This is to certify that Mccarthy Mary C/CPW Development  
has permission to Construct New 46' x 28' Single Family Home  
AT 0 Seventh St 340 C021001

**City of Portland, Maine - Building or Use Permit**

**Dept:** Zoning      **Status:** Approved with Conditions      **Reviewer:** Marge Schmuckal      **Approval Date:** 07/22/2003

MINOR SITE PLAN
 FOR A SINGLE FAMILY HOME
 ON SEVENTH STREET PORTLAND, MAINE

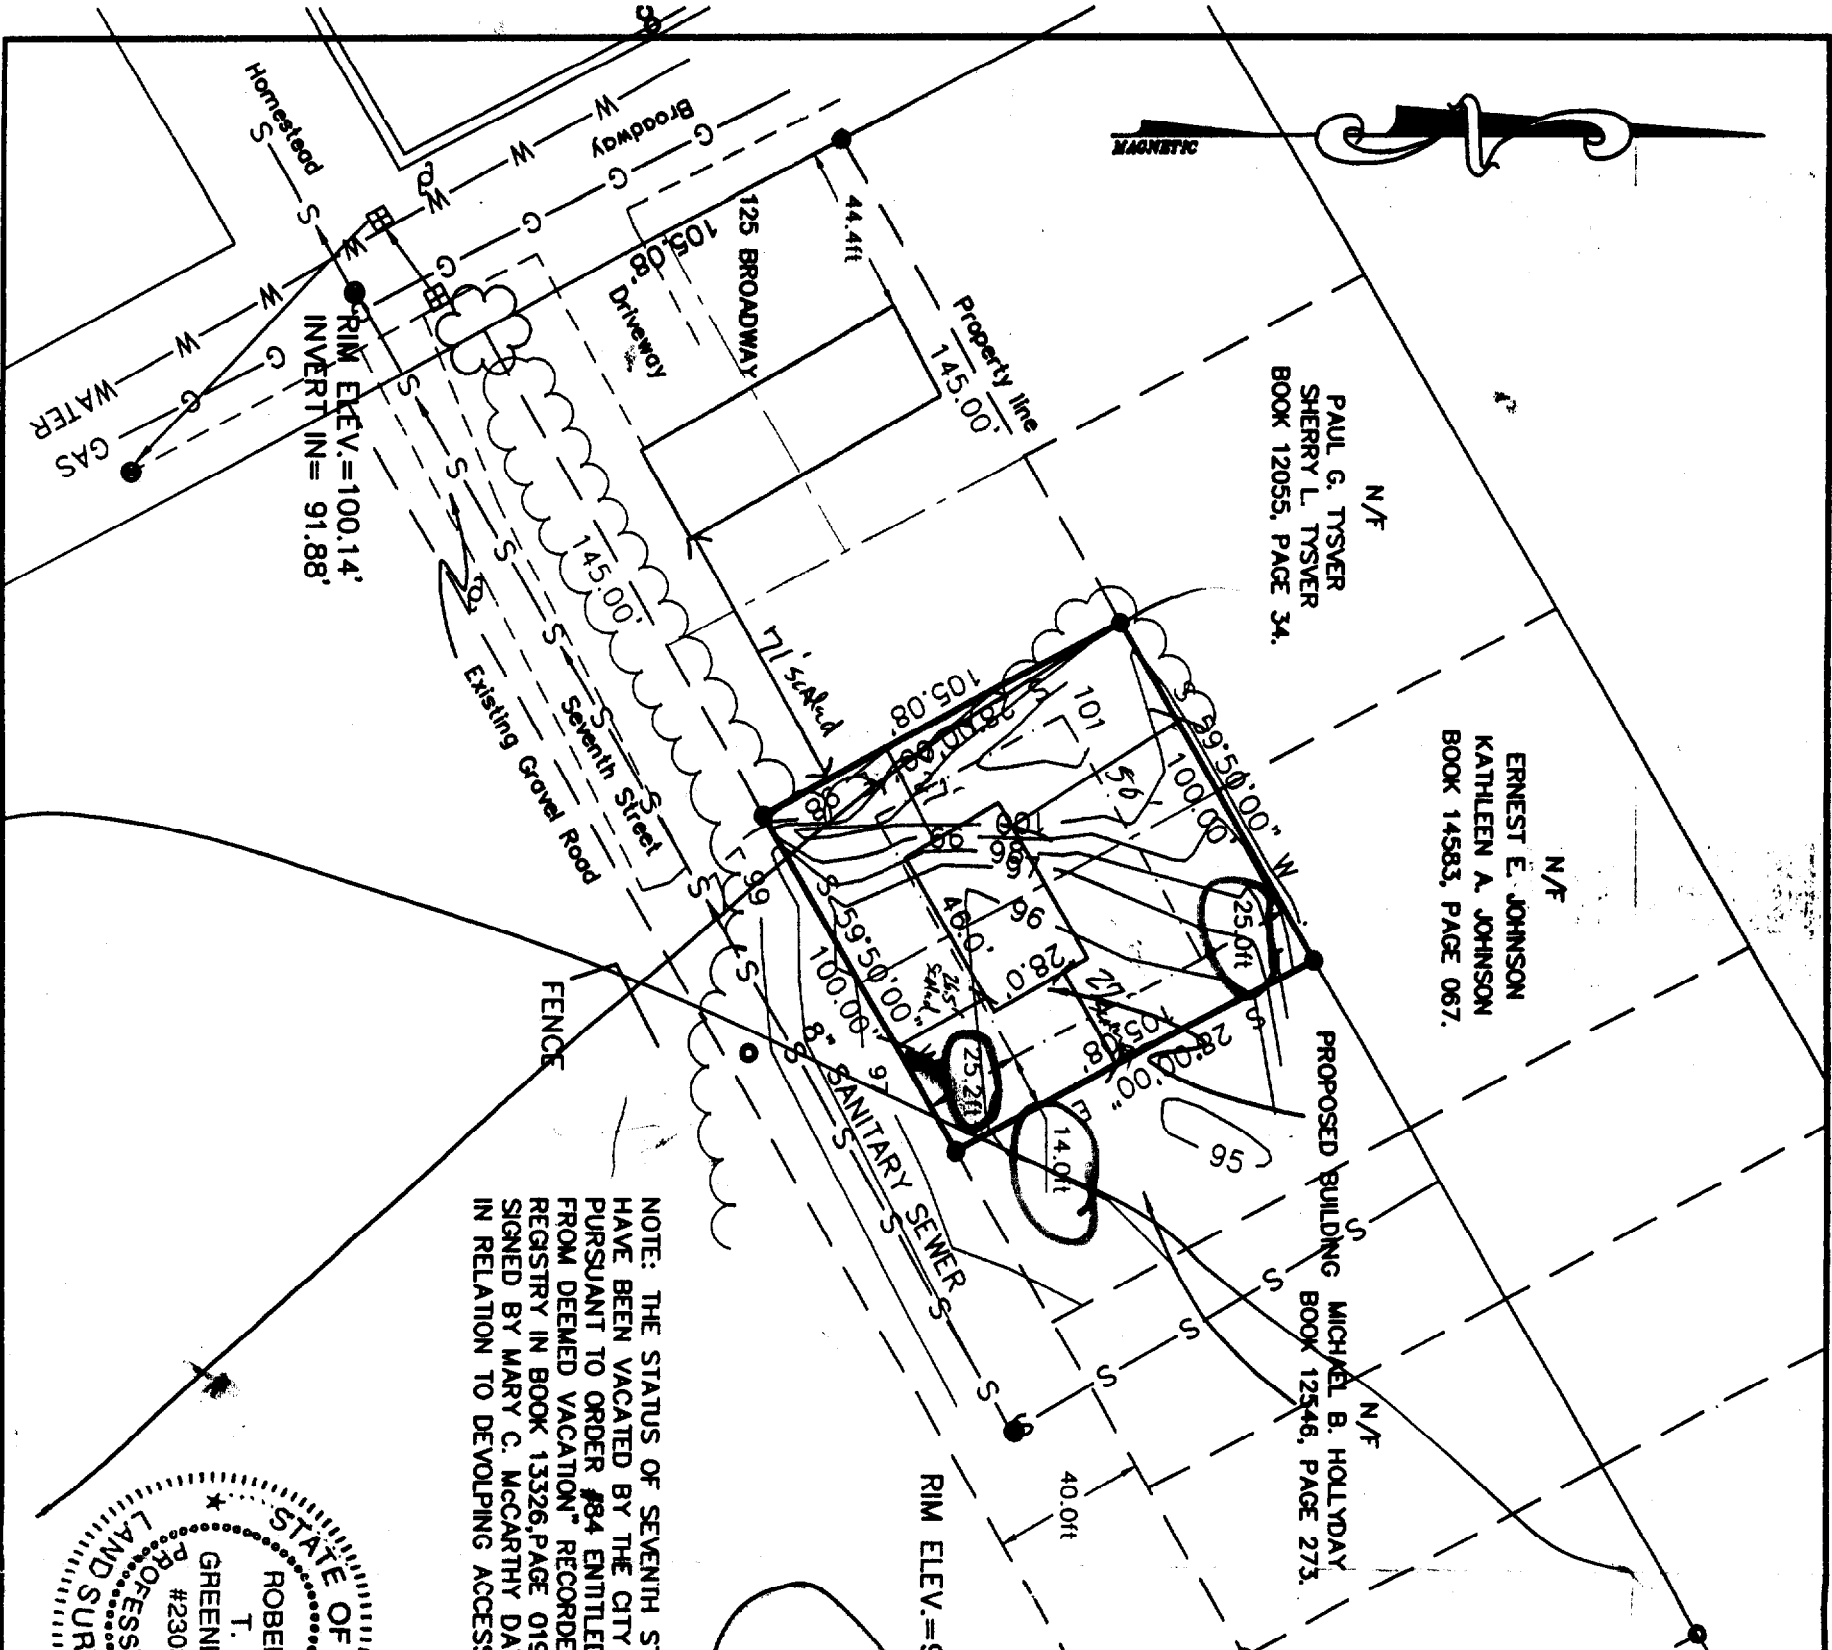
**Note:** 6/24/03 requested a revised site plan showing two parking spaces and front steps - also advised Karen that there was no logging in of minor/minor site plan review (she inputted the information) **Ok to Issue:**   
 7/16/03 - dropped off new plans - only shows parking - I requested to see the front steps also  
 7/21/03 - received revised plans with parking and front steps

Projections - Needs to show front spurs 7/21/03 showed plans 3' x 8' into setback

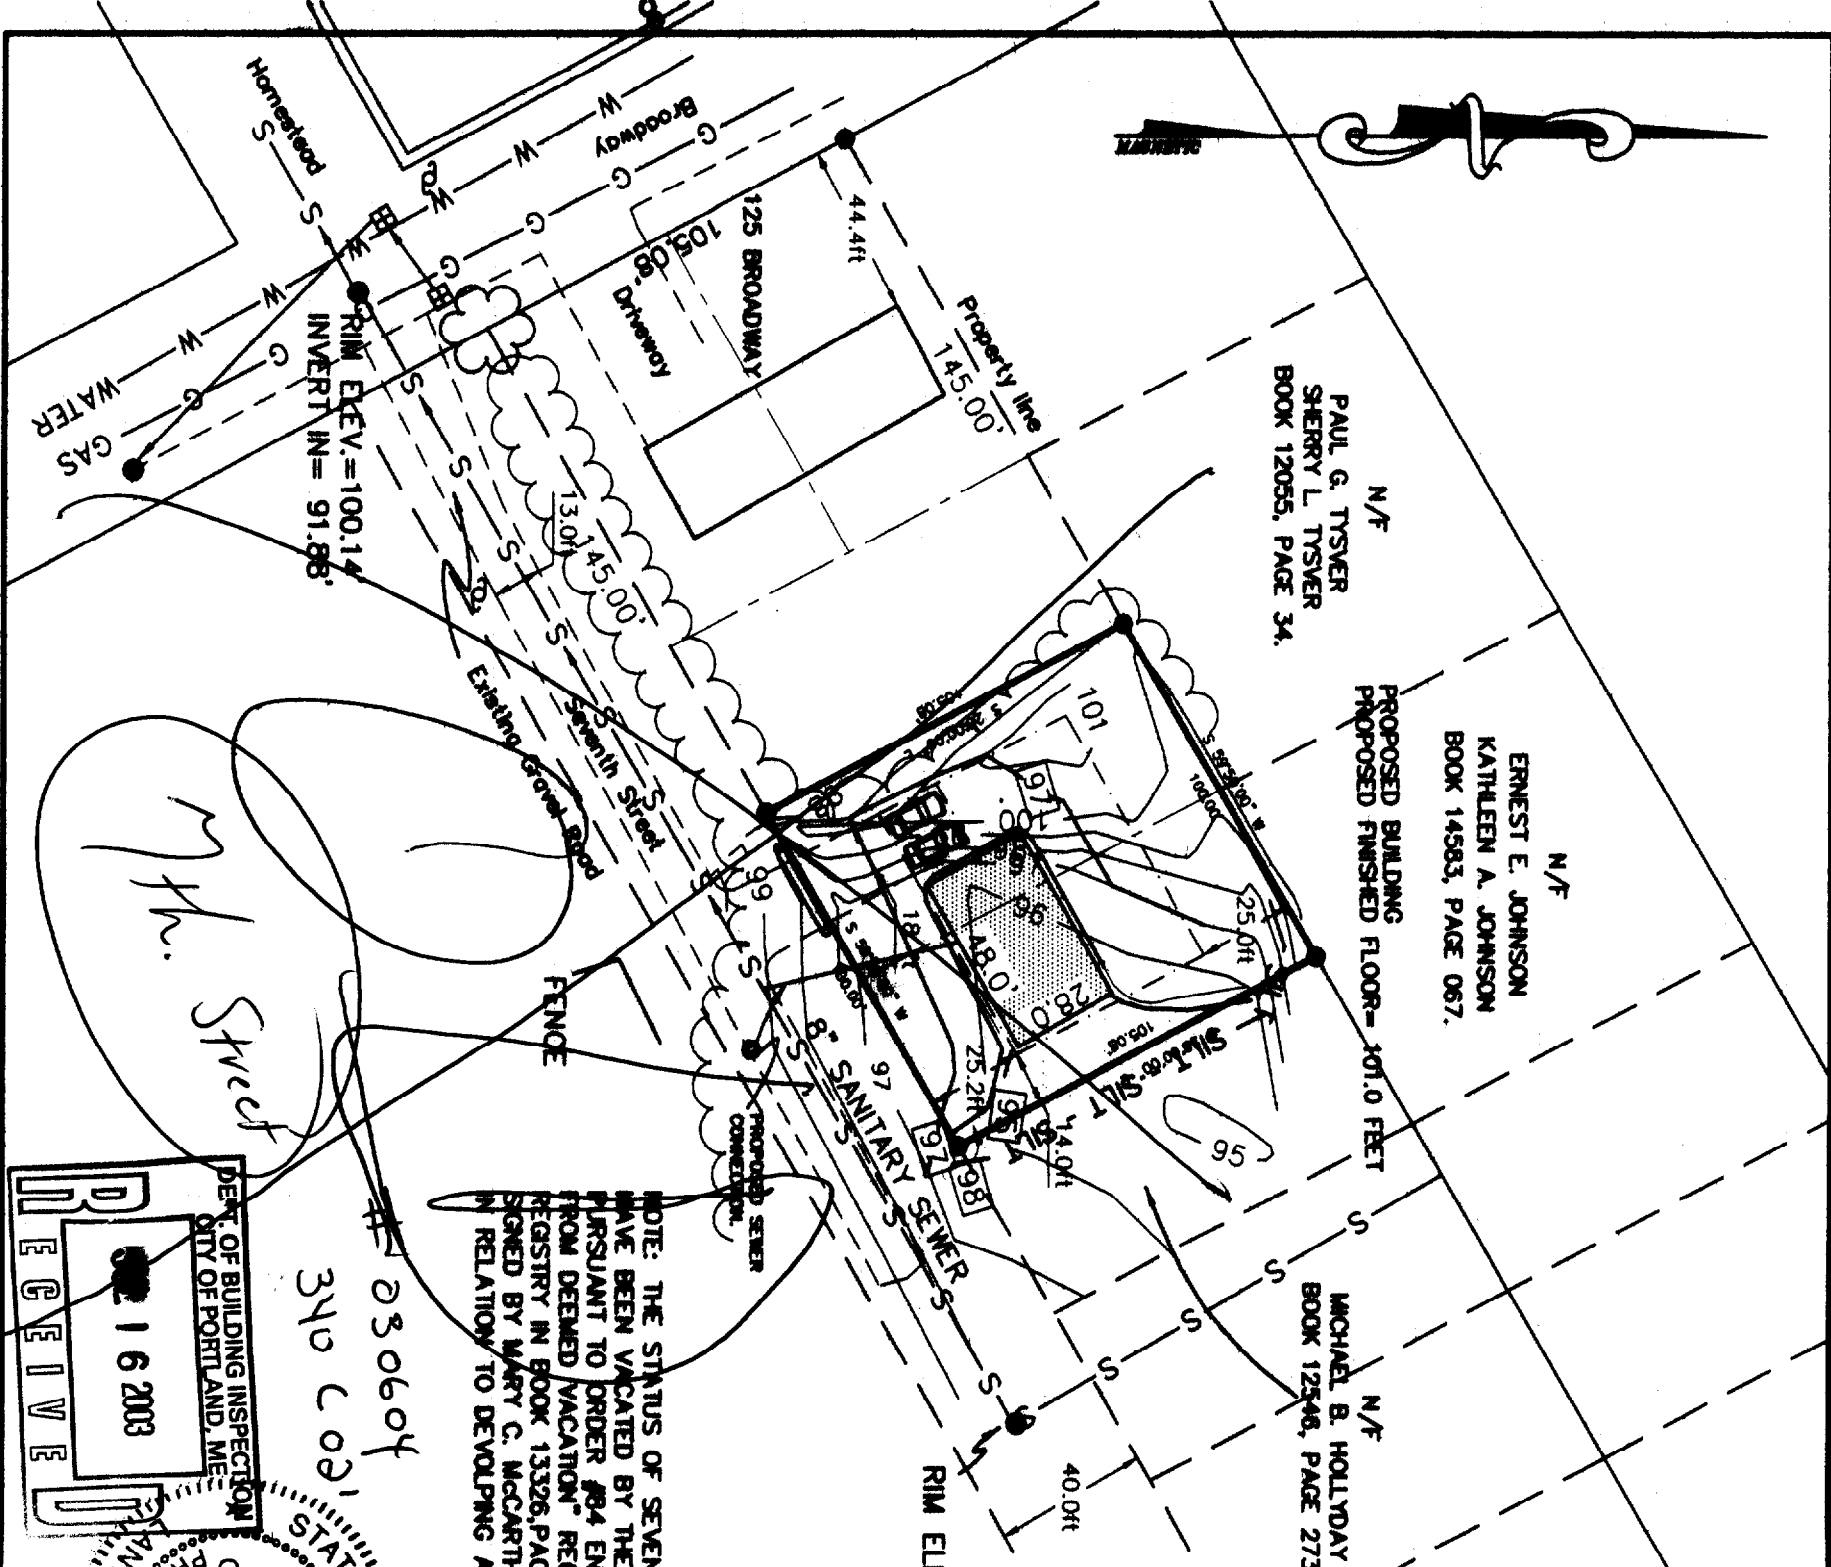
Off-street Parking - 2 spcs req. - None shown
